Burrendong Wind Farm EIS

Application No. SSD-8950984

Submission of Objection

Burrendong Save Our Surroundings

Figure 2: Burrendong Wind Farm LVIA P38 Map. Yellow mark-up identifying Wind Turbine Nos 49, 50 and 53 to 61 along the Worlds End Ridgeline and in close proximity to clients landholdings. Orange 'dots' identify non-associated dwellings not provided in impact assessments.

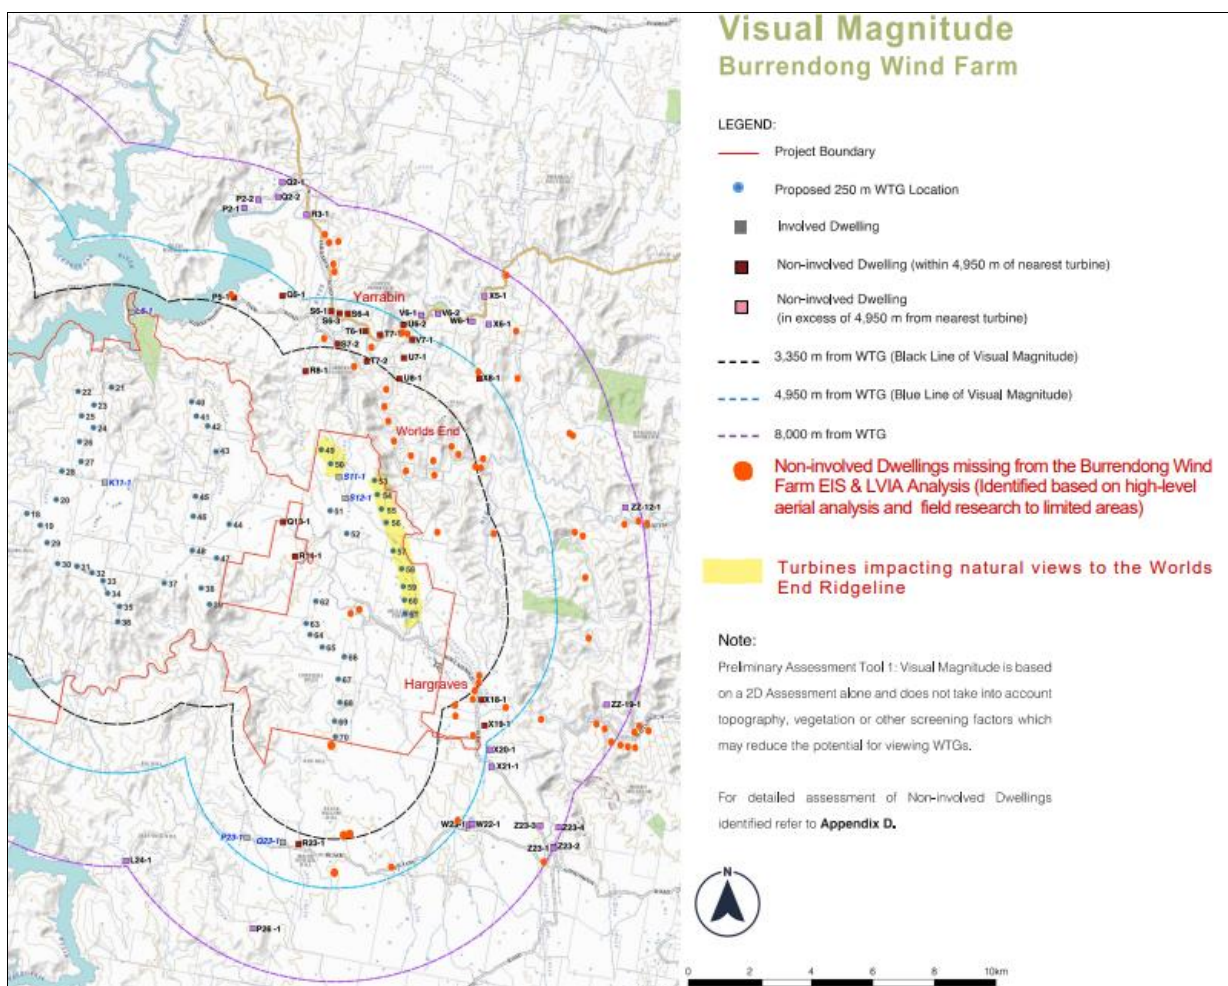
Ark Energy's interpretation of a dwelling as used in the EIS contradicts the assessment requirements of the EP&A Act, the SEARS and the WEG as outlined by the Turnbull International Pty Ltd submission. It has resulted in Ark Energy's unlawful exclusion of approximately 38 (or more) non-involved dwellings located within 4,950m of proposed turbine/s (with approximately 21 of these located within 3,350m of proposed turbine/s) from the Burrendong Wind Farm EIS impact assessments. Dwellings not referred to include for example 100+ year old operational farmhouses.

Please refer to the below map that indicates the general location of these missing non-involved dwellings (orange dots), determined by Burrendong SOS Representatives based on high-level aerial analysis, limited field research and community consultation.

Over 30 dwellings within 4,950m are missing from the visual impact assessment. Refer to the above section 'Definition of a Dwelling-Failure' and associated map above.

250m high industrial turbine Nos 49, 50 and 53 to 61 proposed to sit along and parallel to the Worlds End Ridgeline, will tower above the ridgeline and over 1/2km into the air (to their 'tips') above the relative level of the majority of dwellings located in the eastern valley below.

Visual impact mitigation measures should involve the removal of turbine Nos.40, 41, 42, 43, 49, 50, 53, 54, 55, 56, 57, 58 from the proposal, to eliminate and or significantly reduce visual impacts and lighting from the highest density of surrounding non-involved properties with dwellings and dwelling entitlements located to the east and north-east of the project site. Based on the above considerations and the fact that there will be significant visual impacts created by this development for existing landowners and residents we feel that this ground of objection alone, dictates that the development must fail.

Figure 4: Burrendong Wind Farm EIS – Public Viewpoint Analysis Locations, Burrendong Wind Farm (P118). Marked Up by identifying missing public viewpoint locations.

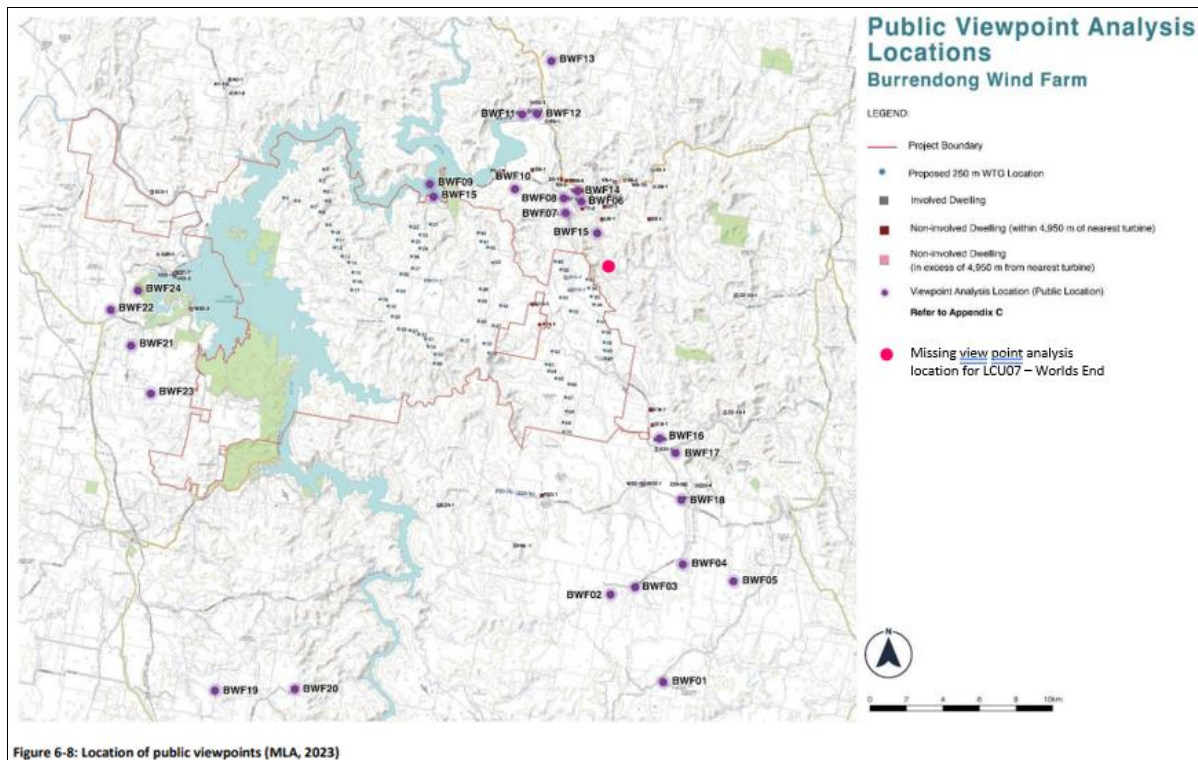
The EIS does not meet the Bulletin requirements because, it fails to identify and analyse the worst-case public viewpoint scenarios. Burrendong SOS requests that the Public Viewpoint Analysis and selected locations be independently assessed.

For example, in our opinion, the worst-case public viewpoint location for LCU07-Worlds End is marked with a pink dot on the below map - to the east of Worlds End Ridgeline and the Meroo River, and affords a High Visual Influence Zone (VIZ) rating of 1 for LCU07. Even though the proponent consultant visited the pink dot location in March 2023, it selected an alternate public viewpoint (BWF15) with a lower visual impact and assigned a low VIZ rating of 3 for LCU07- Worlds End. The description of BWF15 in the LVIA fails to identify the Worlds End Ridgeline that is highly valued by surrounding landowners and residents. This deviates from the worst case scenario analysis required by the Bulletin.
